10-lot plot BOCC Public Hearing

LP-18-00002 Suncadia Ph 3 Div 14

Public Comment

Site Development Plan Phase 3 Division 14 Tumble Creek July 18, 2018

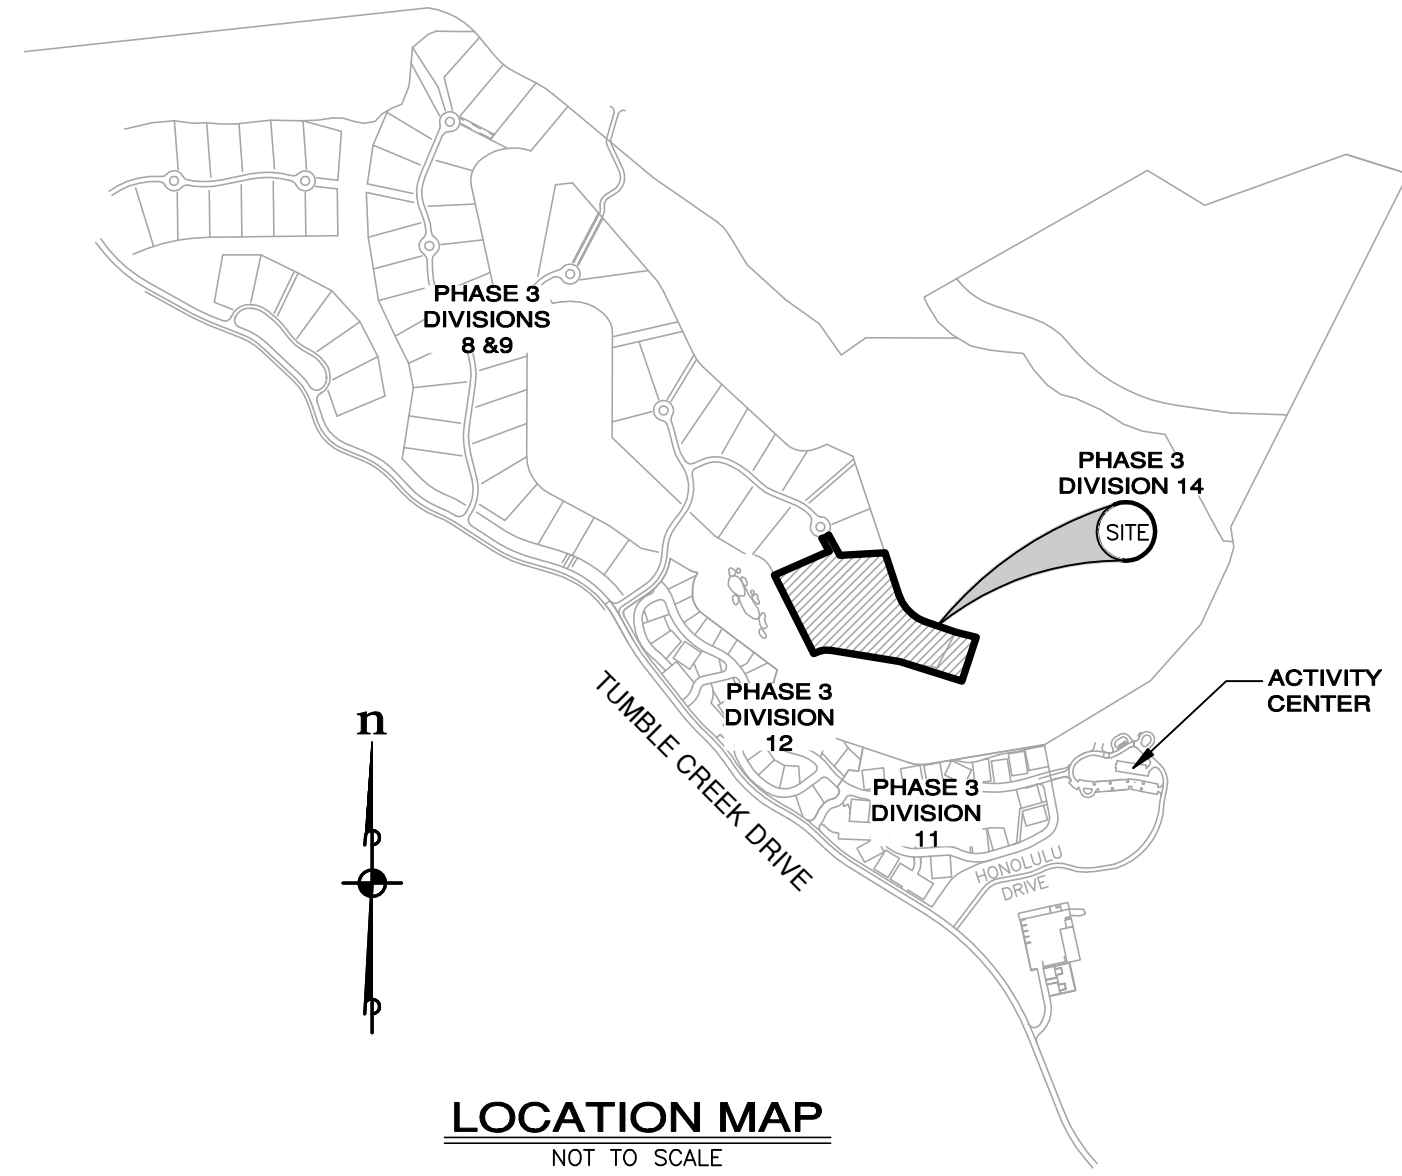
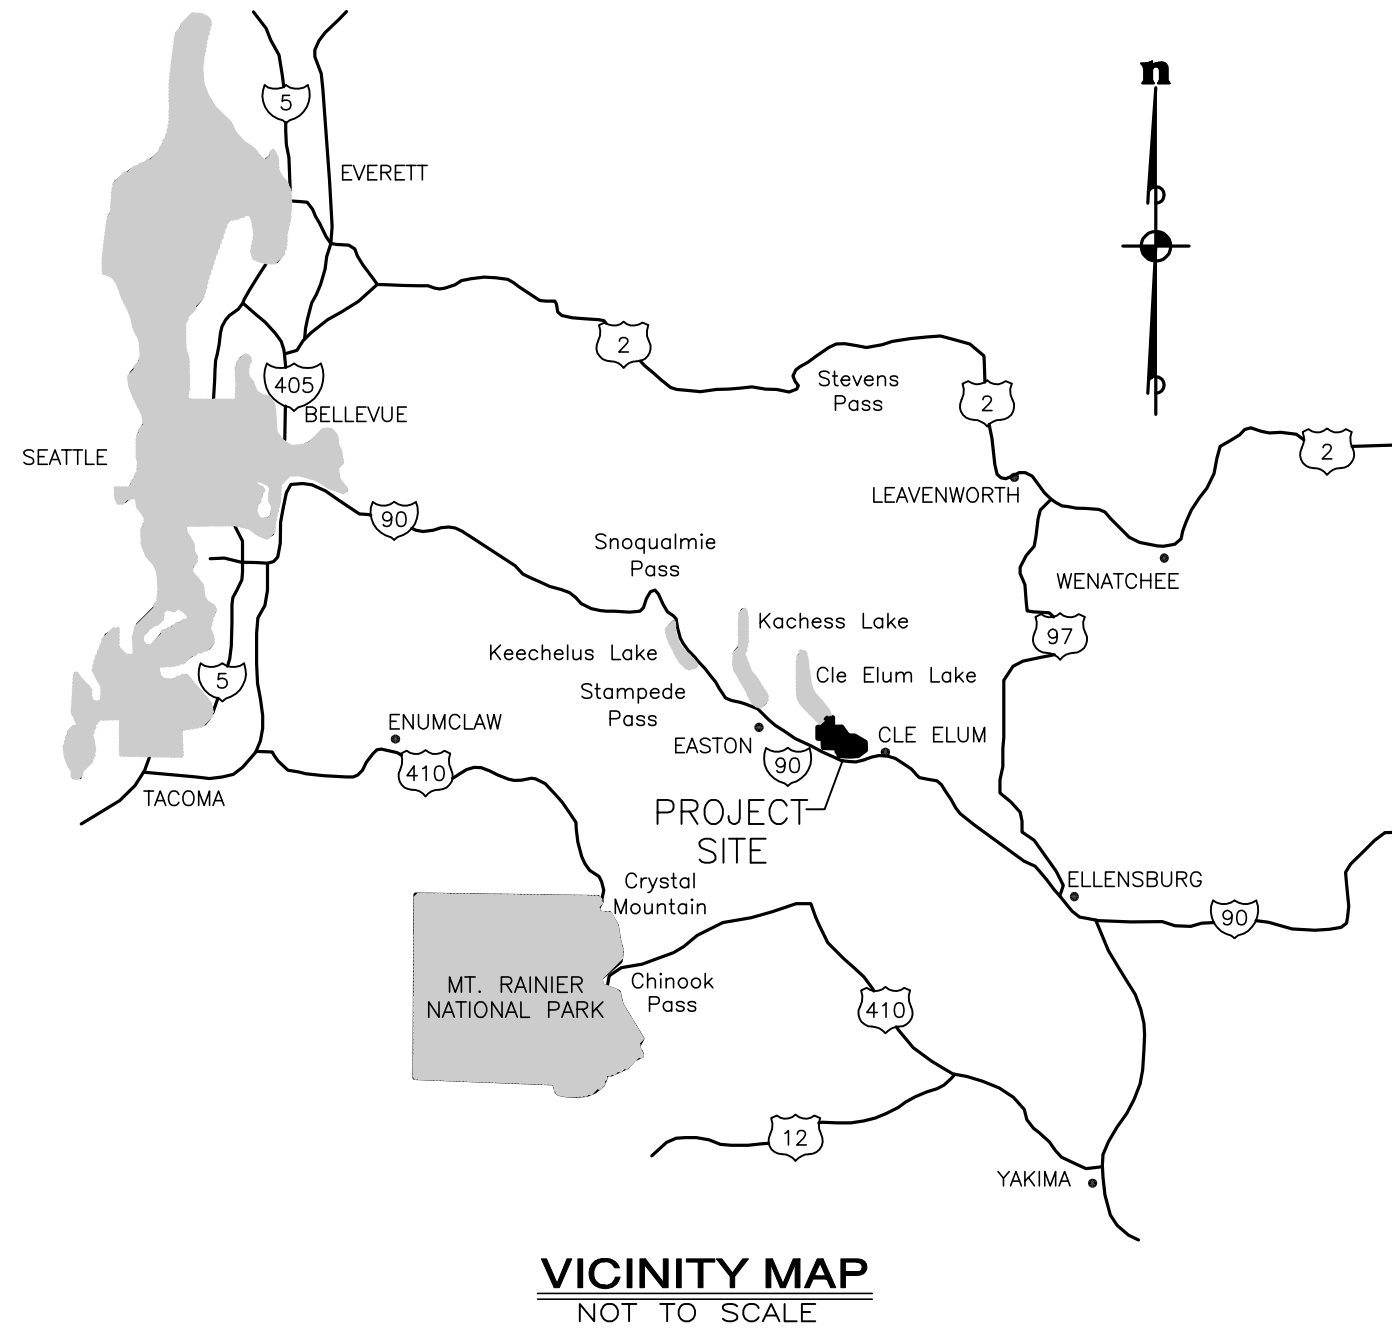
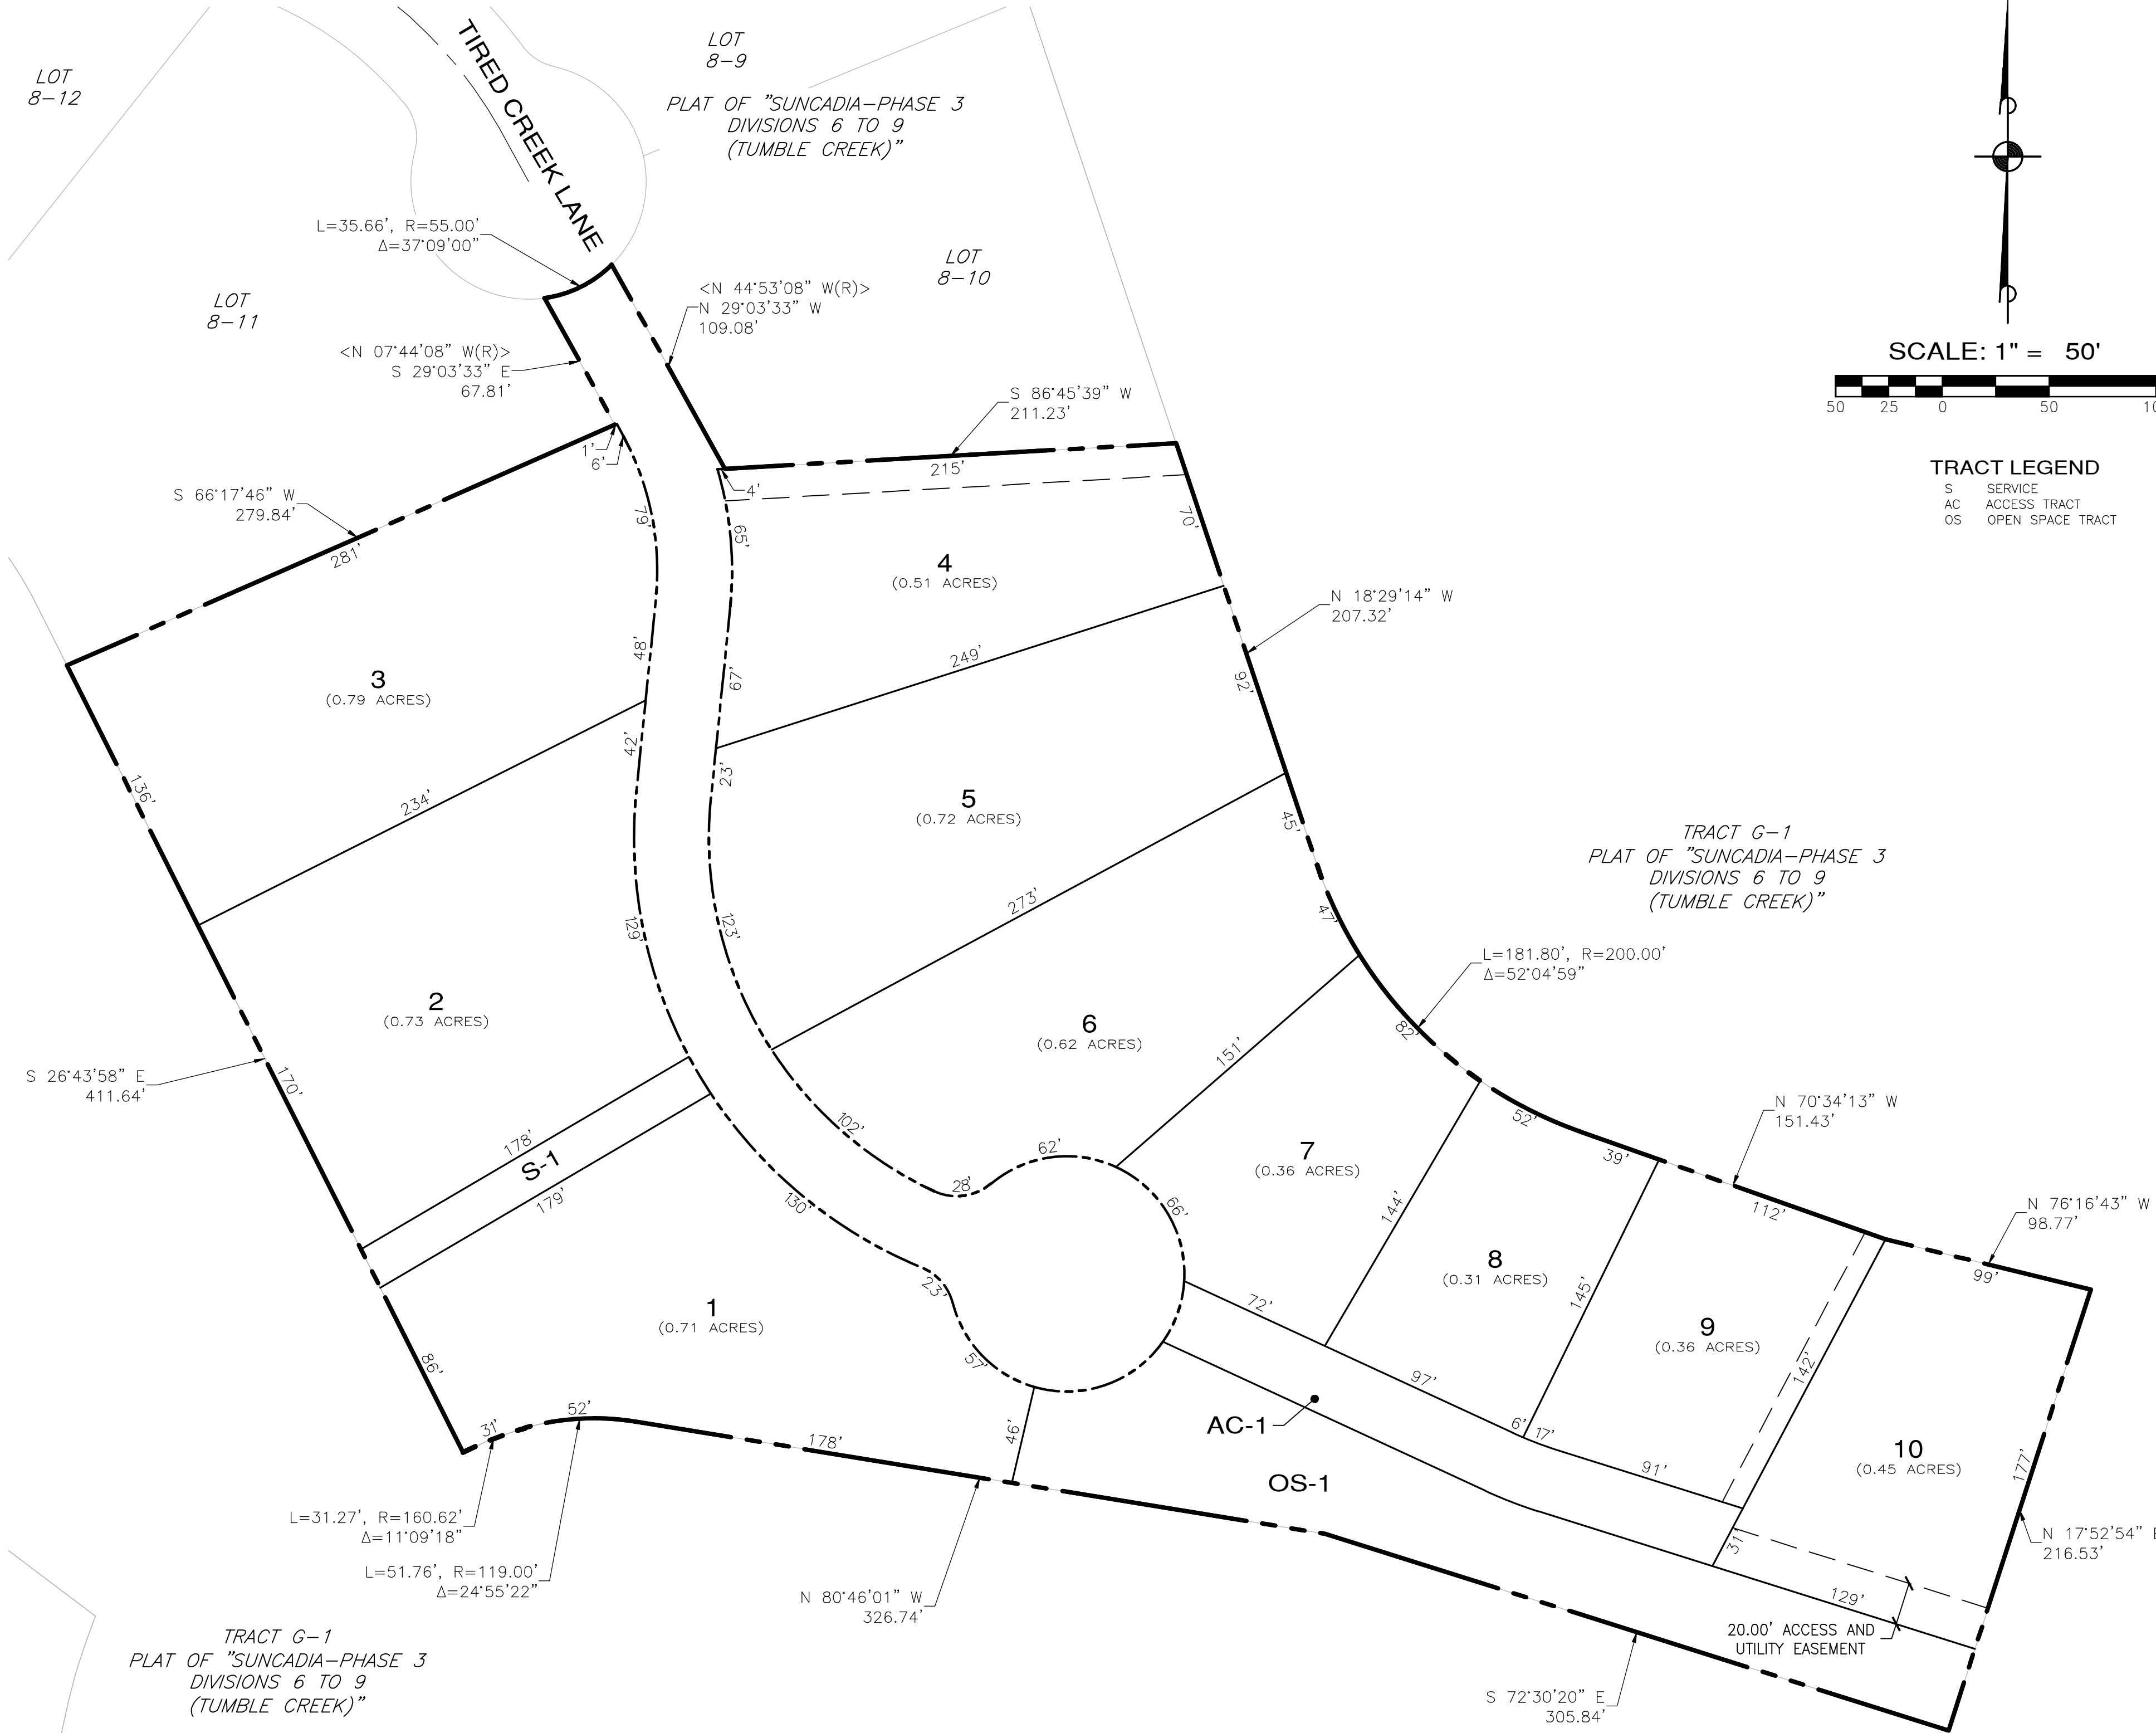
- requesting 30' height on residences

- describes property & handouts -
- lot 10 is unnecessary and removes views
- only allow residents @ 30' & only allow 9 lots, most issues go away.

- significant concerns on Environmental impact
- legal team does not agree w/ consistency finding mainly bc of lot 10
- deny & reconfigure for 9 lots w/ new proposal.
- restrict height to same as existing cabins

- concern is w/ 10th lot because not inline w/ what we purchased
- concerned w/ seismic issues & potential land slide risk, should require geotechnical report
- plan to clear cut 6 acres, concerning
